Carriage Lane Duplex *Lot #2*  
 Project Name/Description

December 27, 2005

RE: Applications for Carriage Lane Duplexes, Lots 1 and 2

Upon review of the site plans, the City's Planning Division has the following comments:

Project: **Lot 2 Lot Layout and Utility Plan**
CARRIAGE LANE

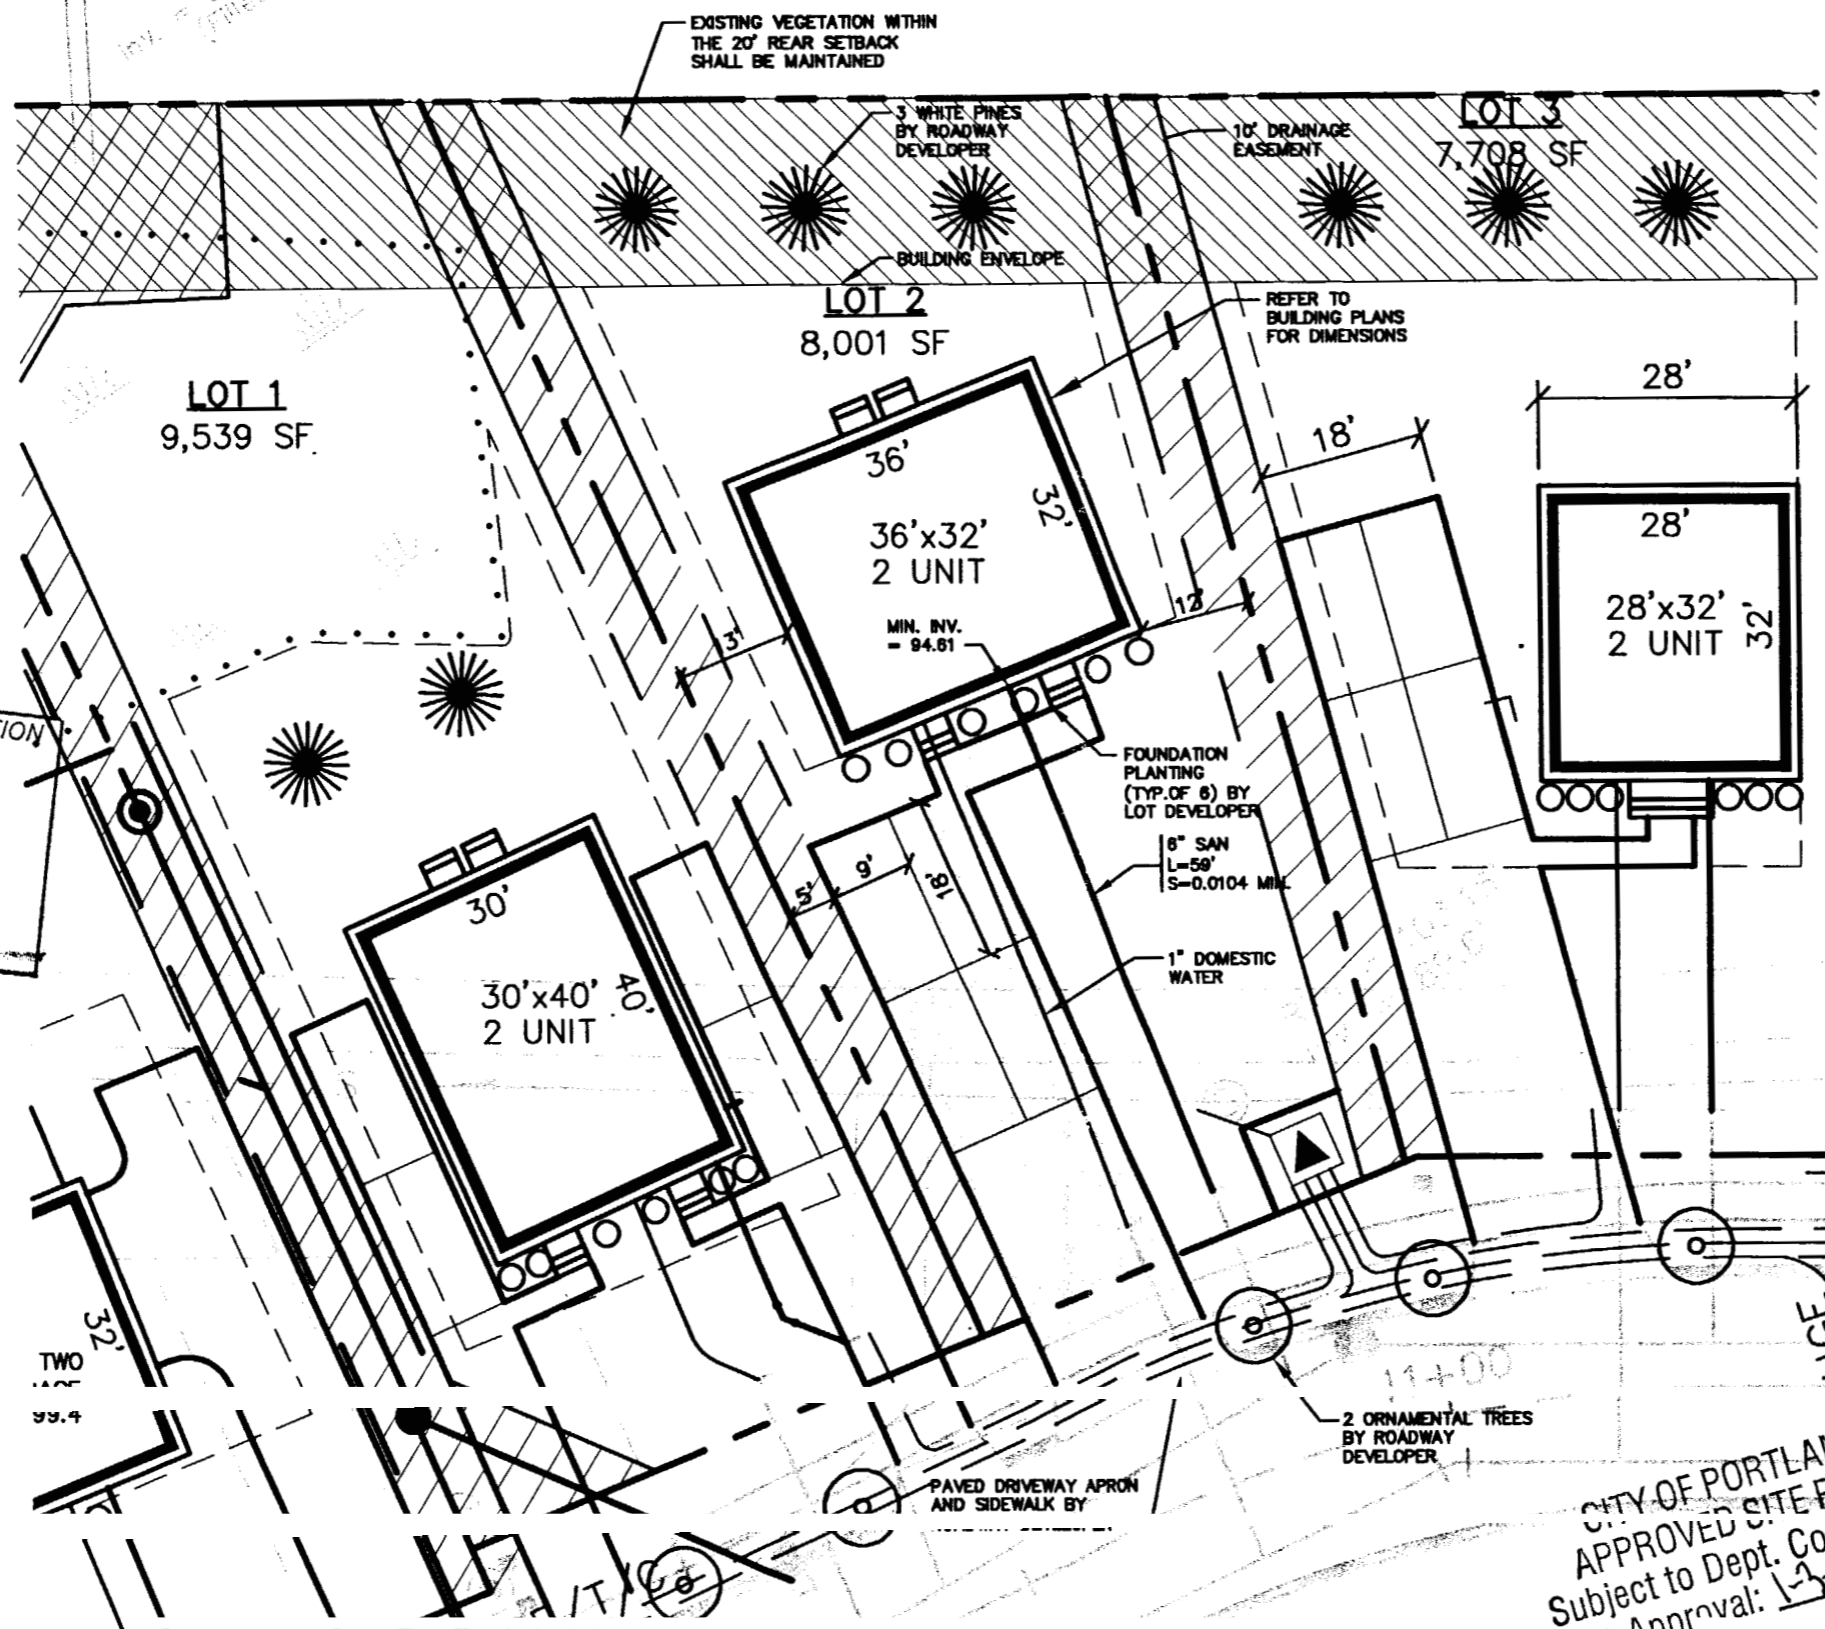
1. Lot #1:
  - a. The proposed easement shown in the front/left portion of the lot has not been finalized by the developer. An amended subdivision plat is needed for the Planning Director's signature, then it needs to be recorded at the registry of deeds. Also, a mylar and 7 paper copies of the recorded version then must be delivered to the City.
  - b. The porch/stairs and the site plan do not match.
  - c. The scaling appears to be off.
2. Lot #2:
  - a. There are a number of lines on sheet #1 that have no meaning. Please label or remove them.
  - b. The porch/stairs and the site plan do not match.
  - c. The scaling appears to be off.

Please submit 4 copies of (each lot) revised plans to my attention.
